## Site plans - building permit

**Jeremiah Bartlett** <jbartlett@portlandmaine.gov>  
To: Helen Donaldson <hcd@portlandmaine.gov>  
Cc: Mike Tremblay <mtremblay@portlandmaine.gov>

Thu, May 7, 2020 at 8:35 AM

Here are my comments on the plans from MMC:

PAVEMENT MARKING DETAILS

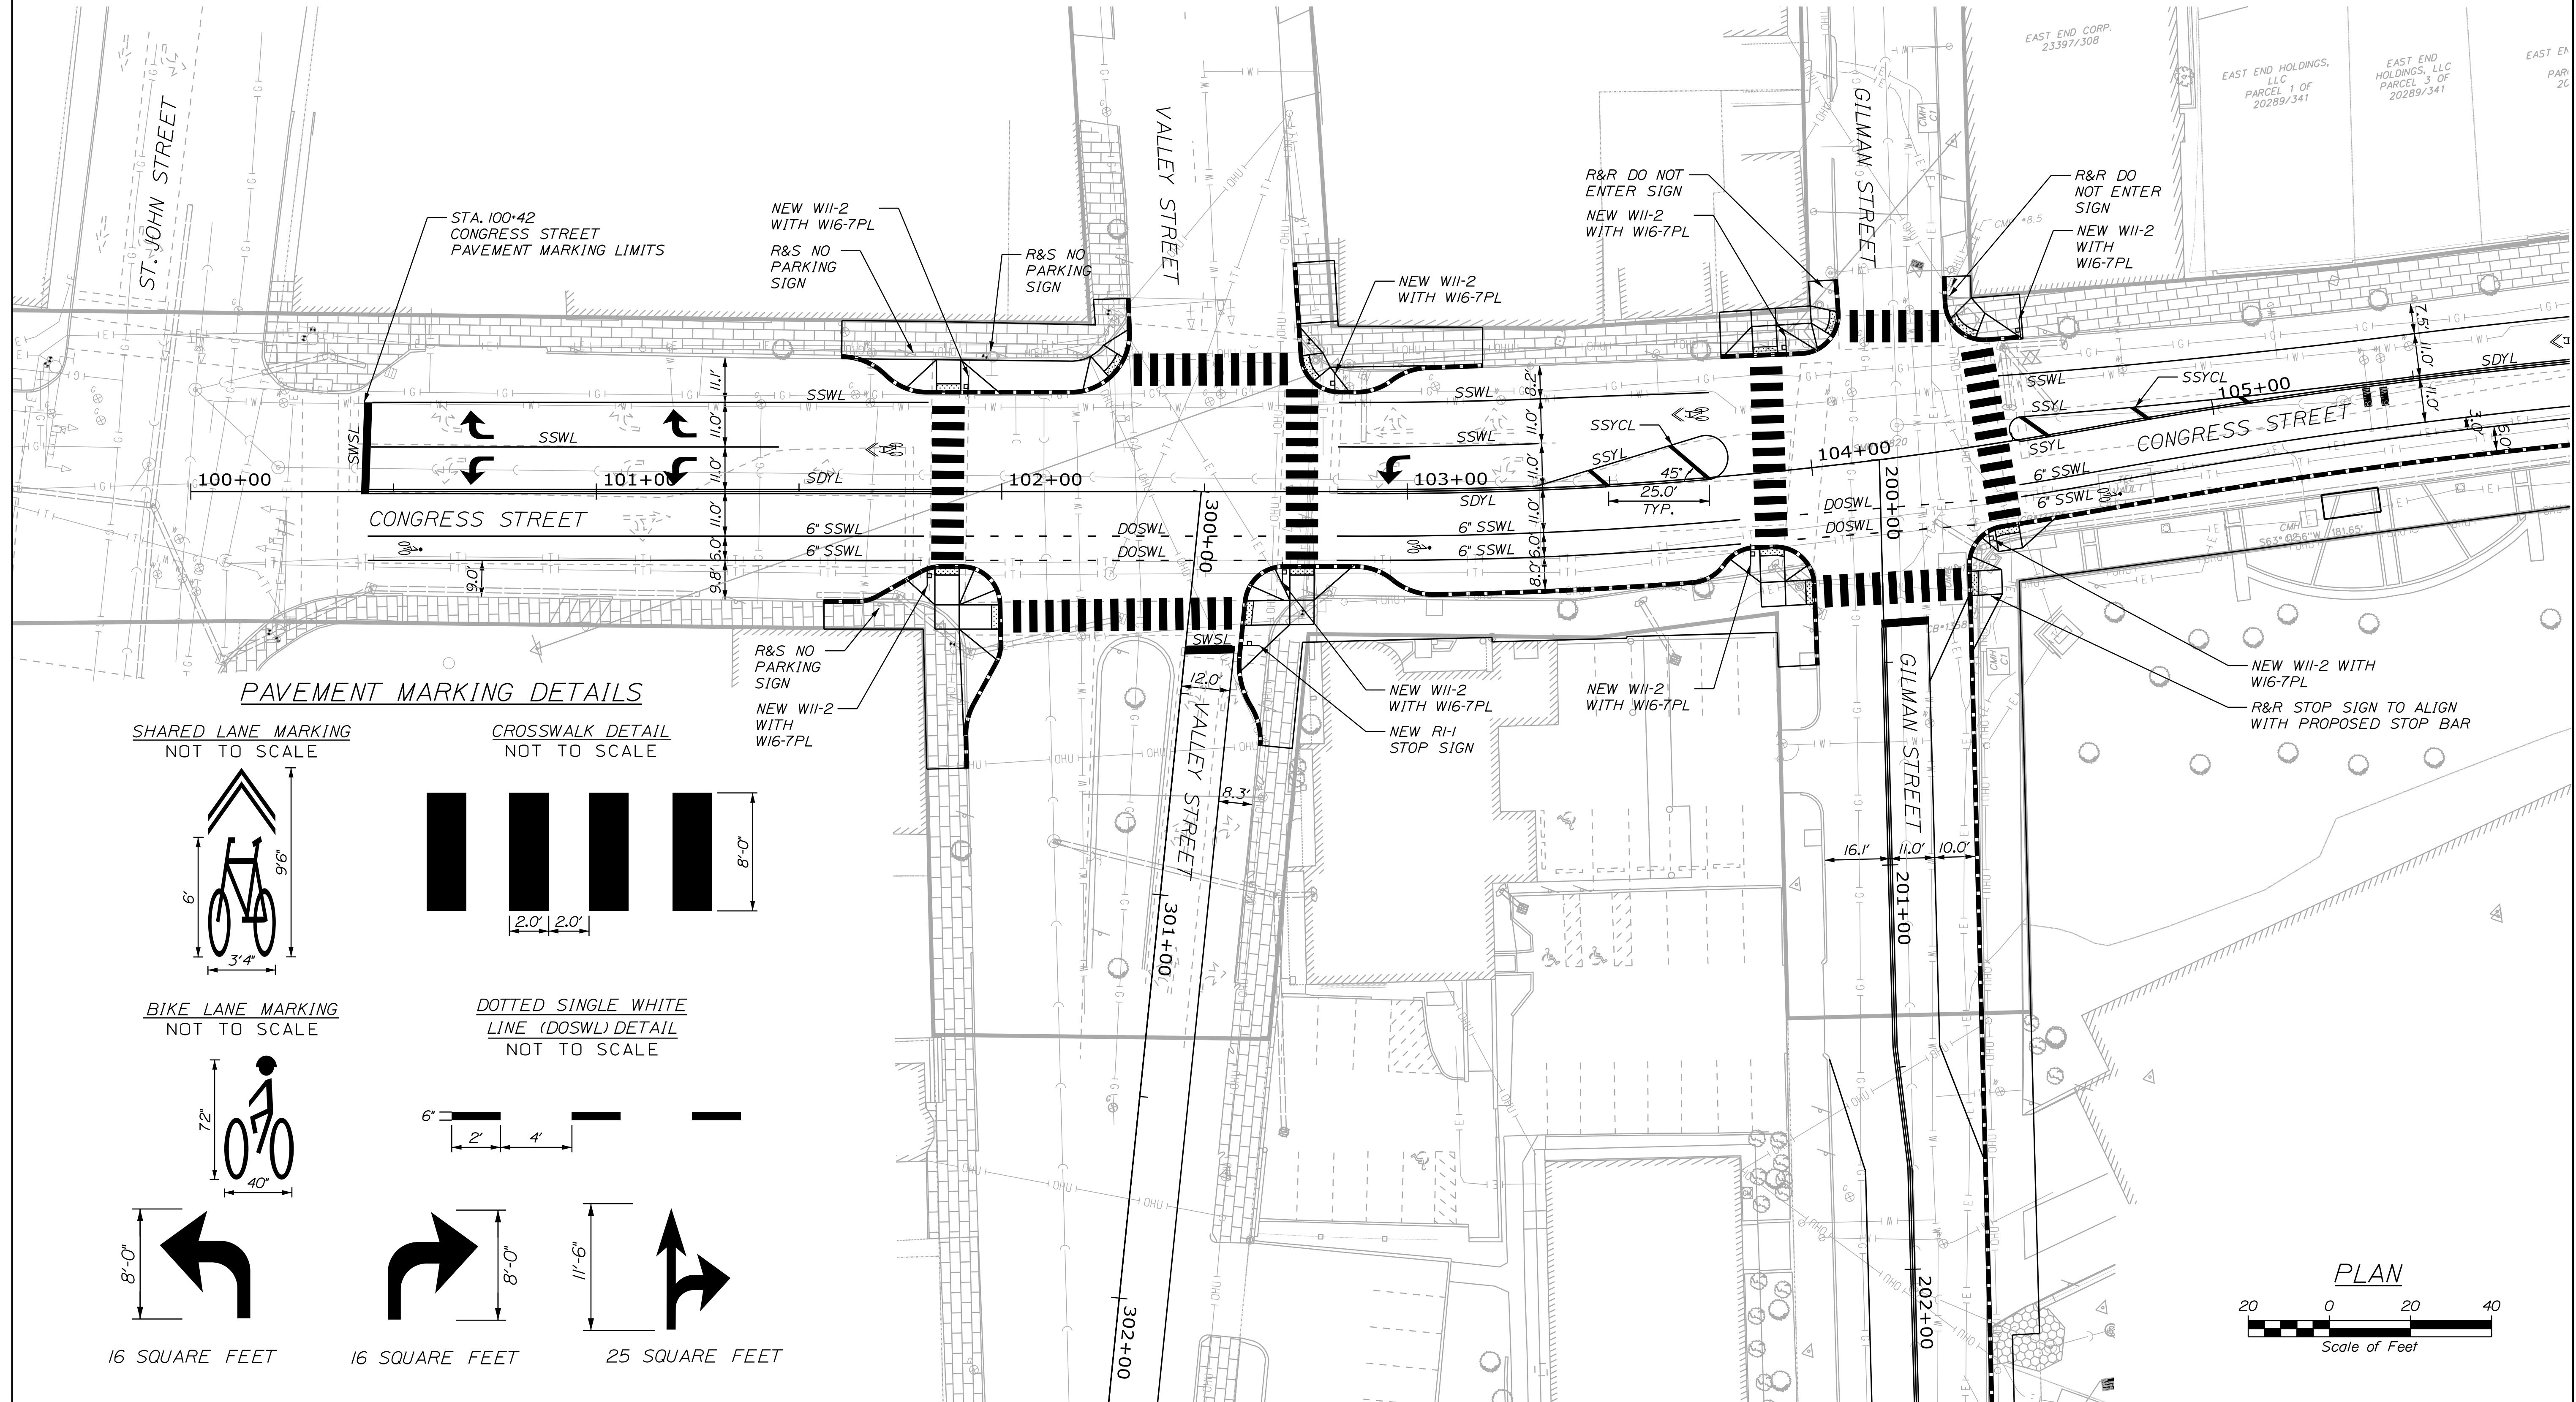
- 3.) The symbol for bicycle lanes should show the City and MUTCD standard helmeted cyclist.
- 4.) The plans do not indicate a phased approach to the street improvements. At a minimum, the improvements shown on the west side of the Congress/Valley intersection should be completed PRIOR to removal of the signal here.

SHEET 9 OF 16

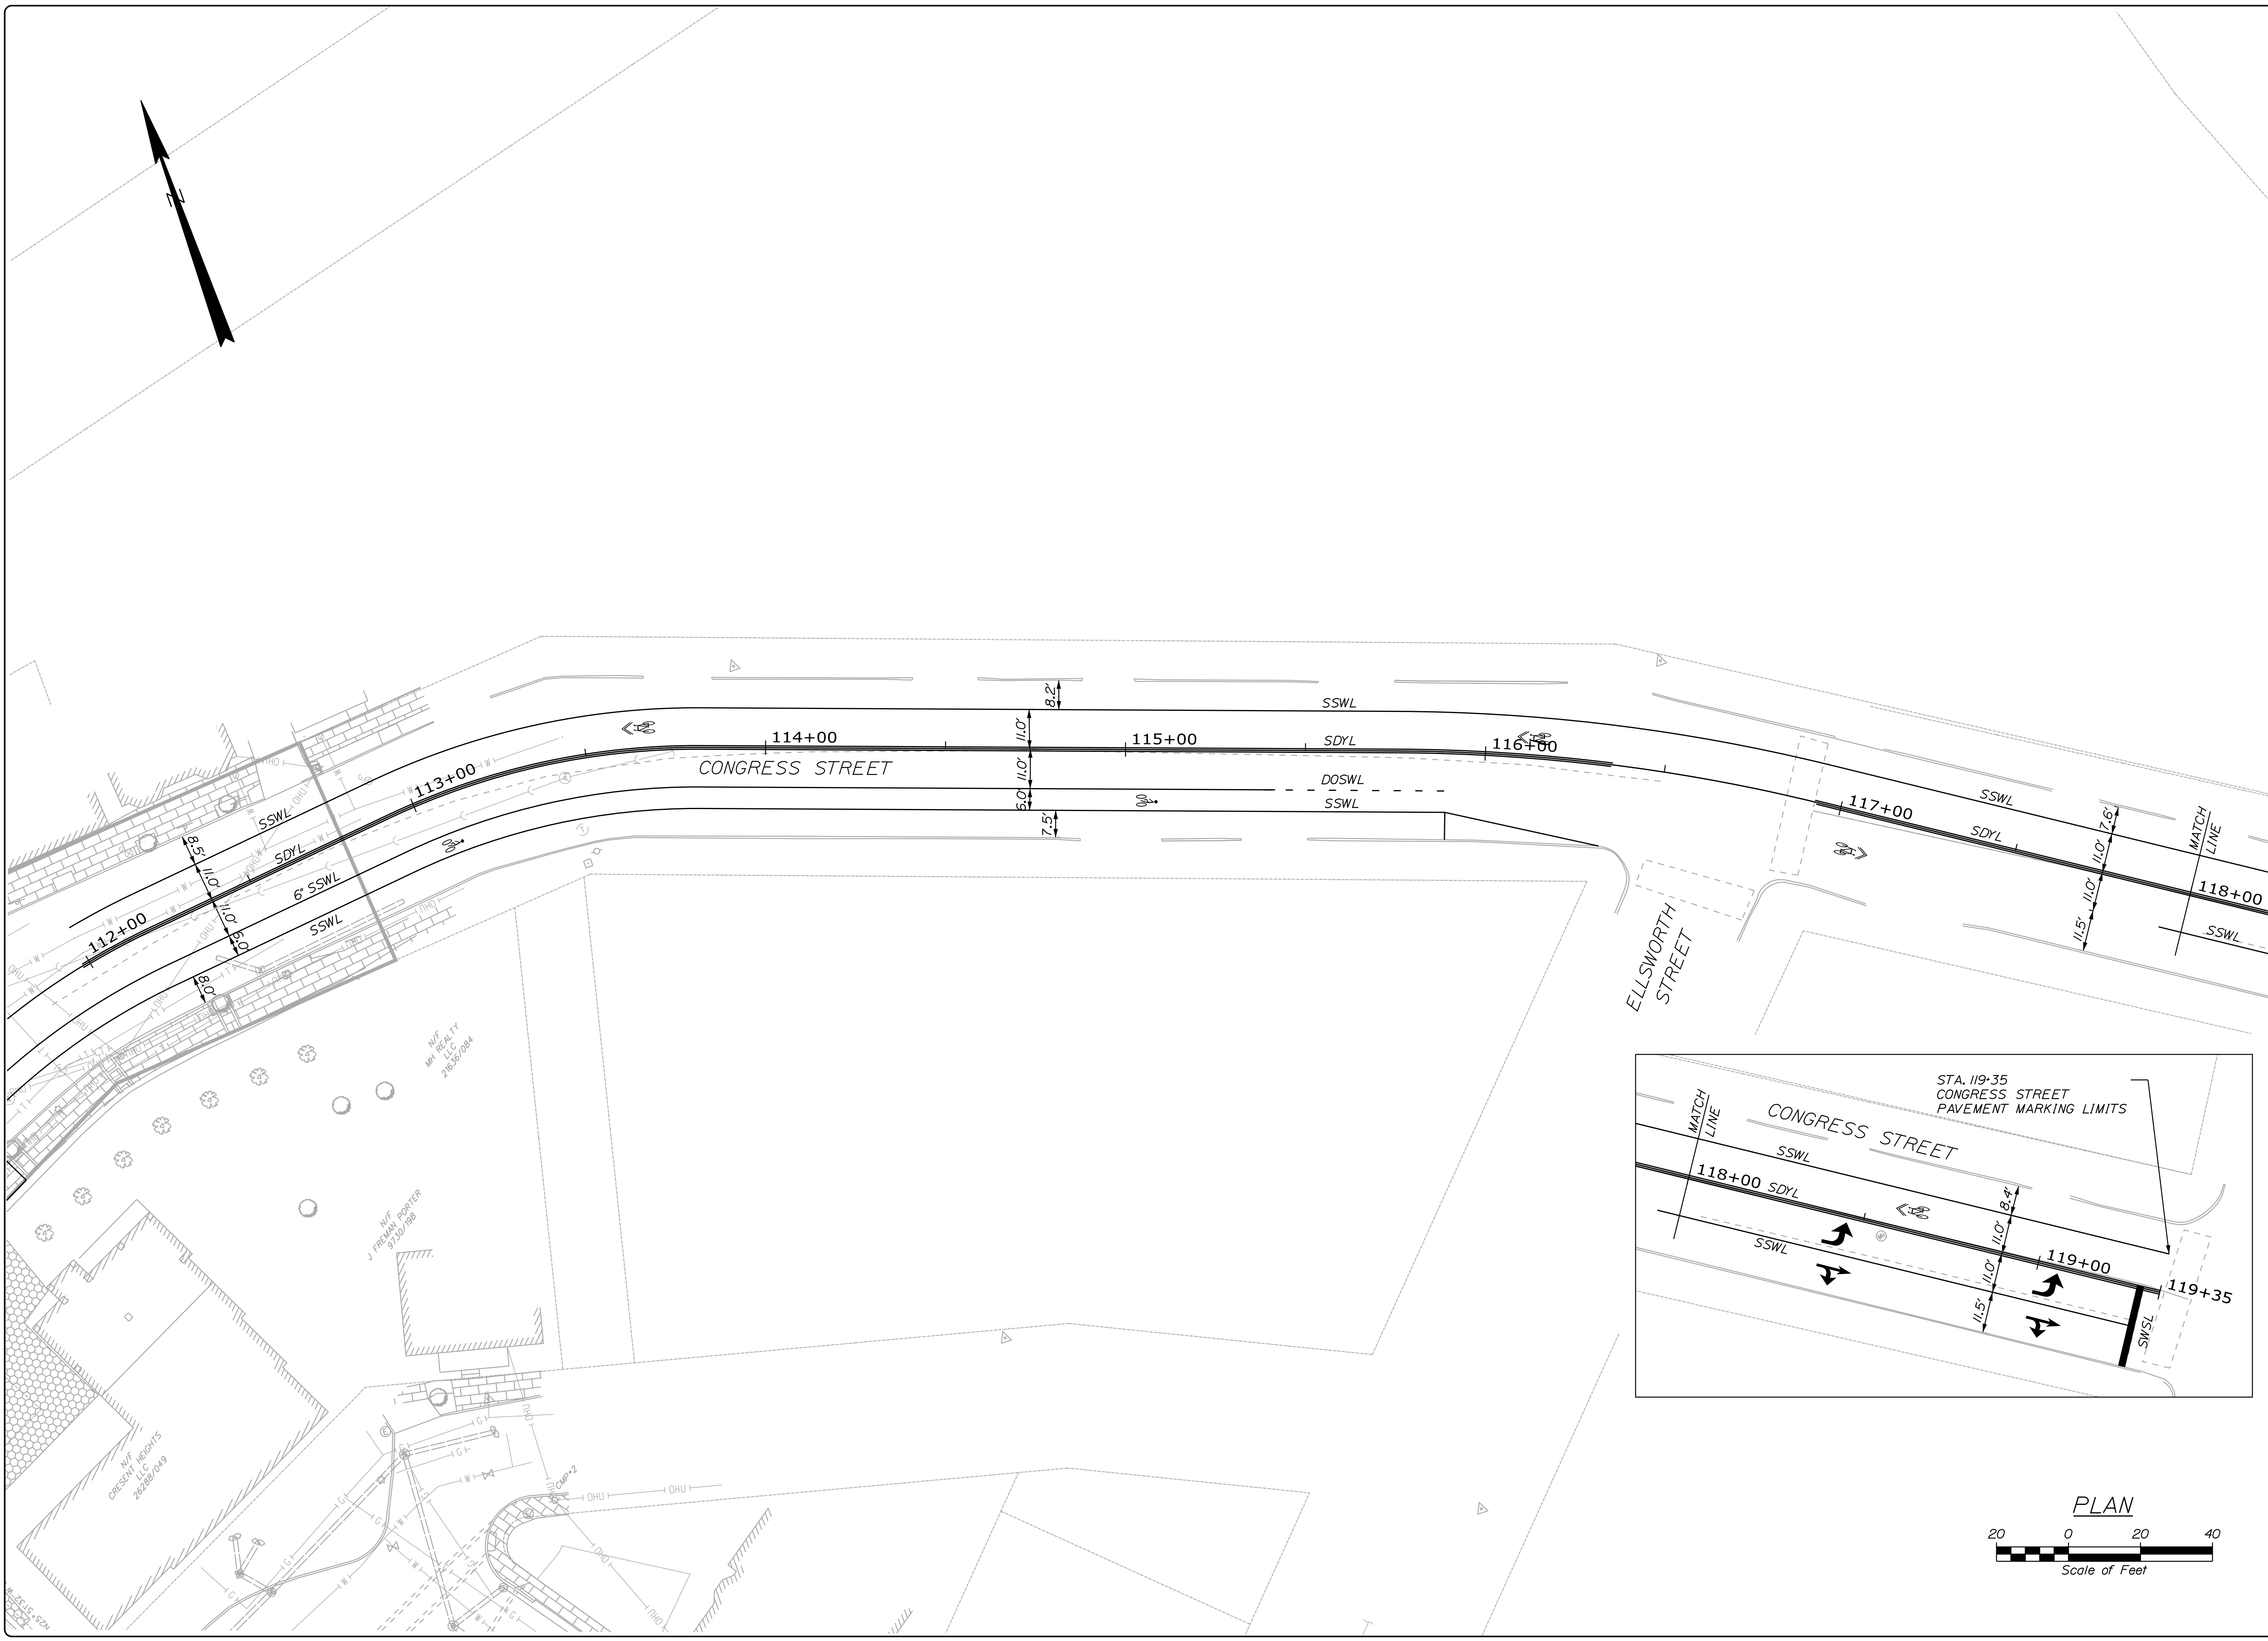
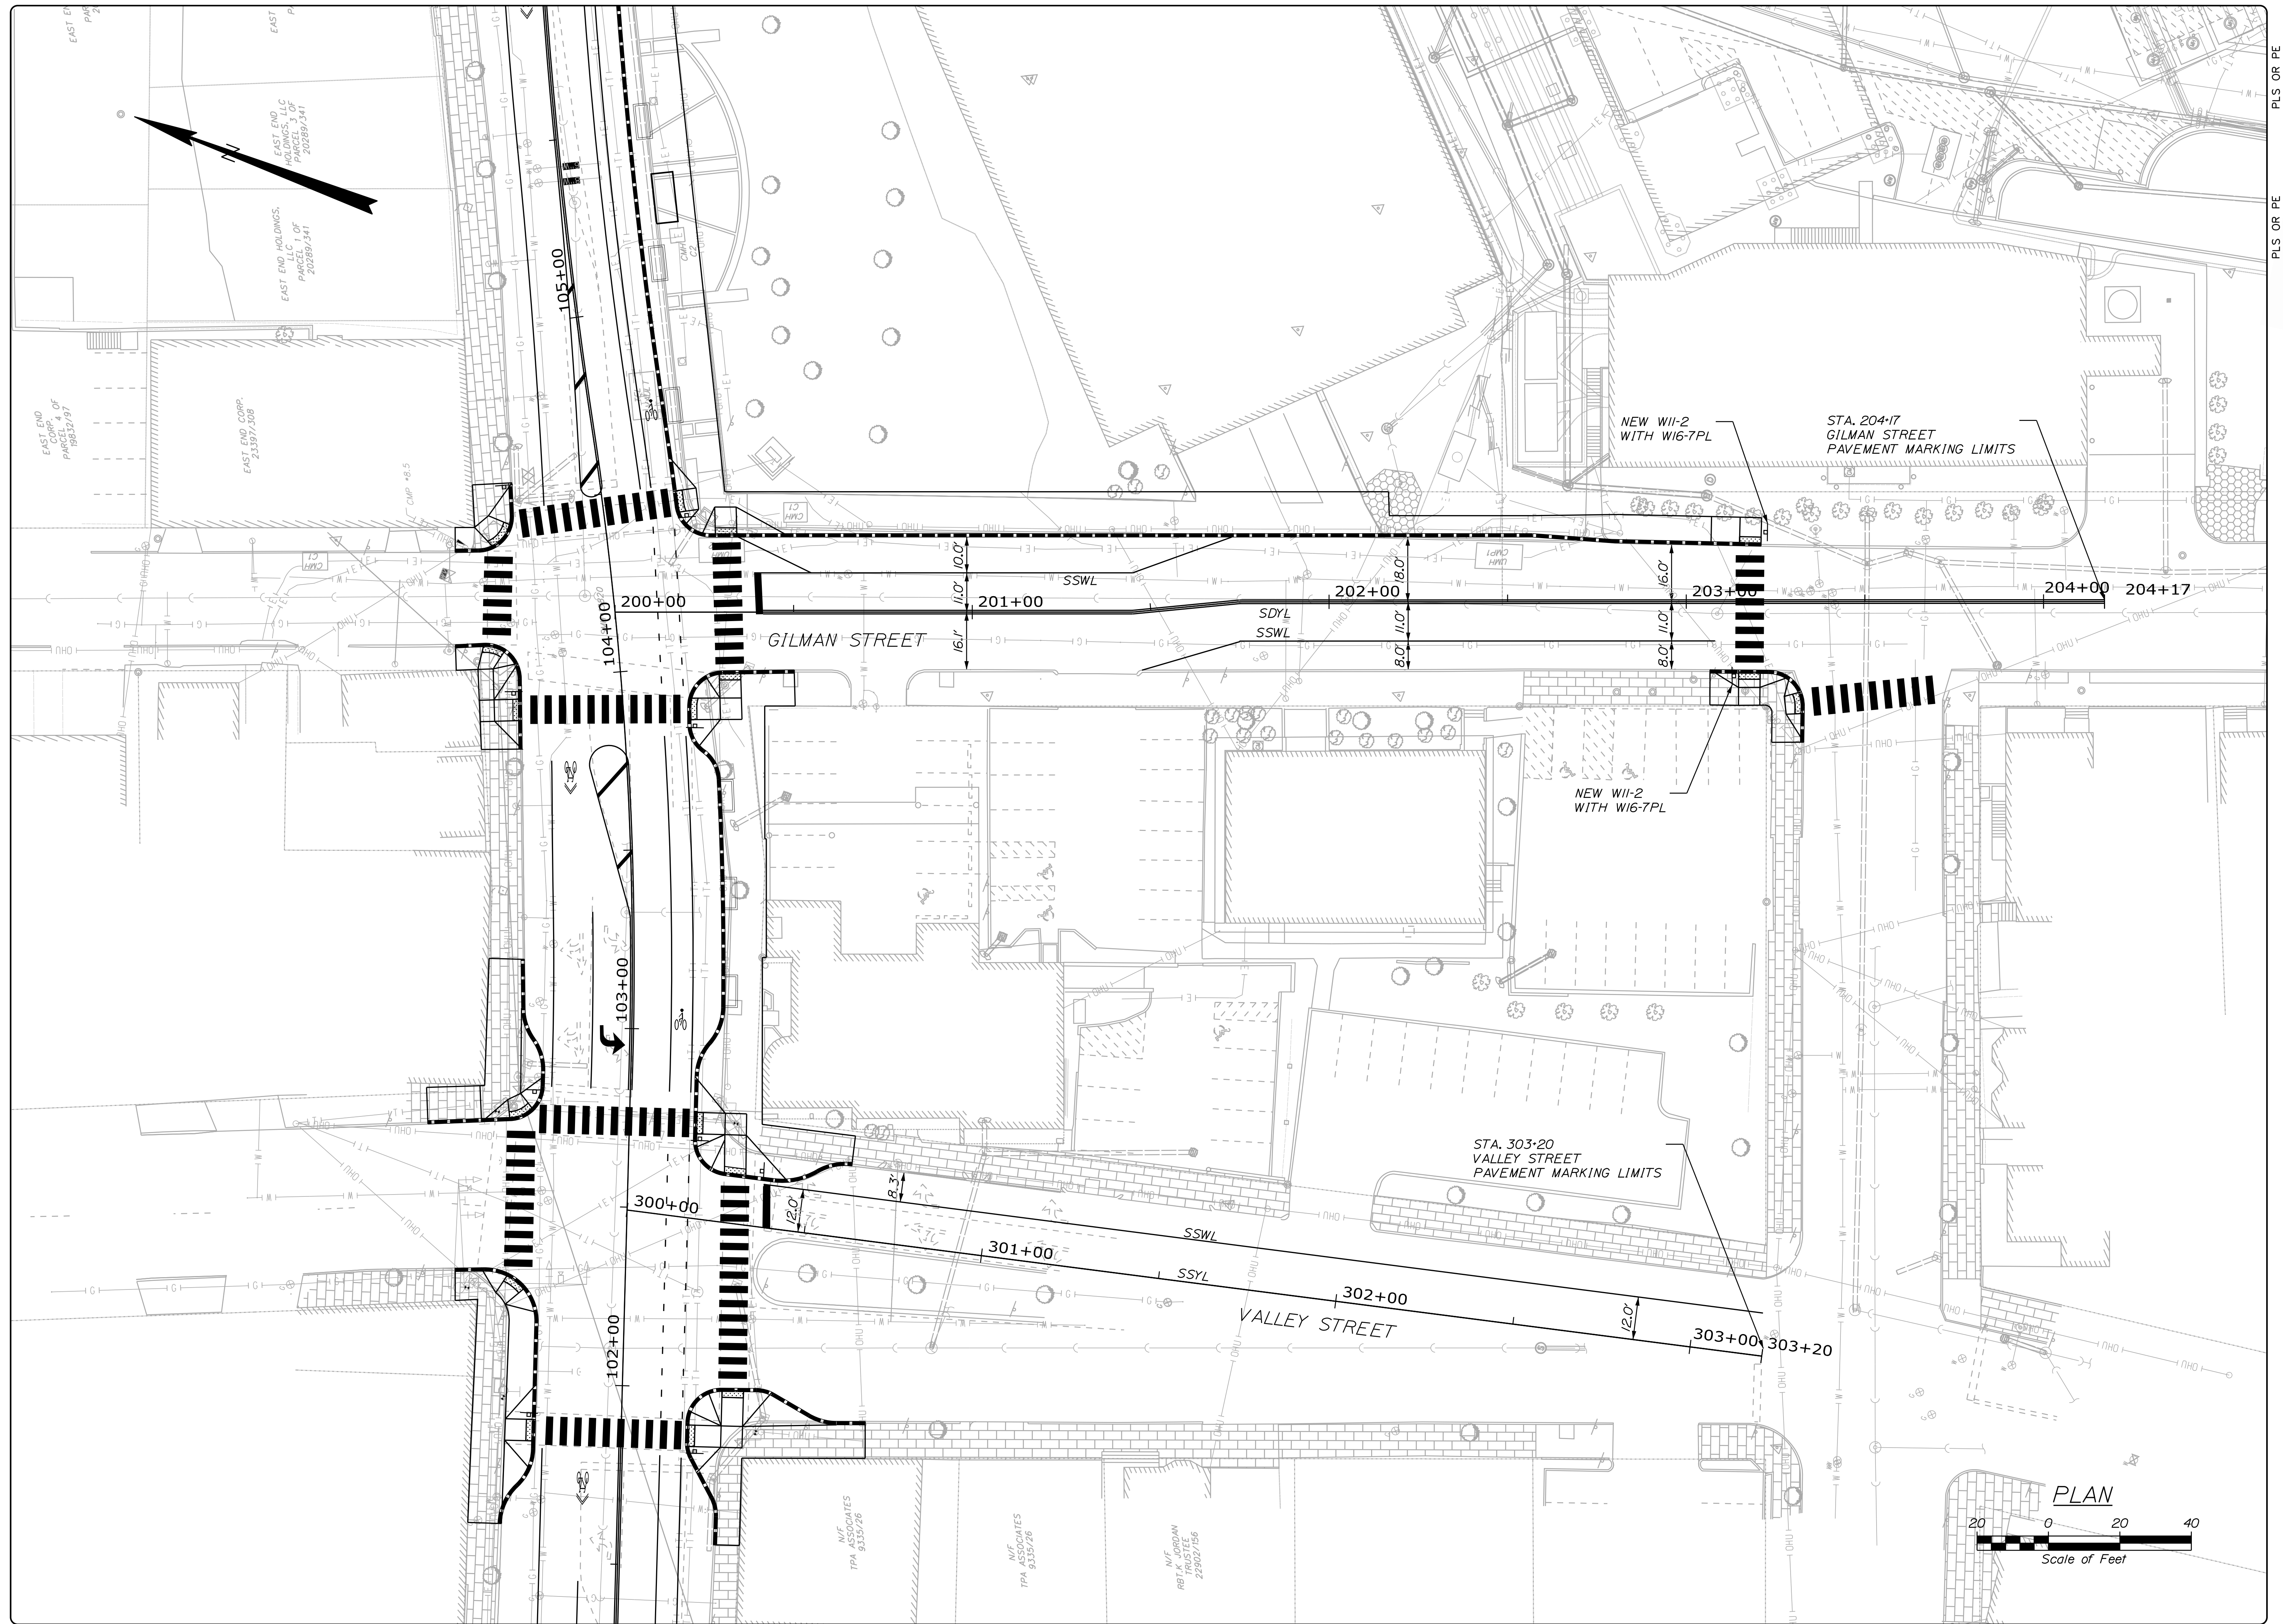
- 1.) The plans show significant runs of concrete sidewalk. Unless this was associated with a specific site plan or due to steep roadway grades, all sidewalk should be in brick. In particular, I cannot figure out why the plans show the south side of Congress between Valley and Gilman in concrete.

- 2.) Most of the proposed ramp designs look acceptable. However, they should endeavor to avoid showing abutting tip down pieces at adjacent ramp areas, as this results in curb "points" that tend to be damaged during winter operations. Reduced curb reveal between ramps is acceptable to address this situation.
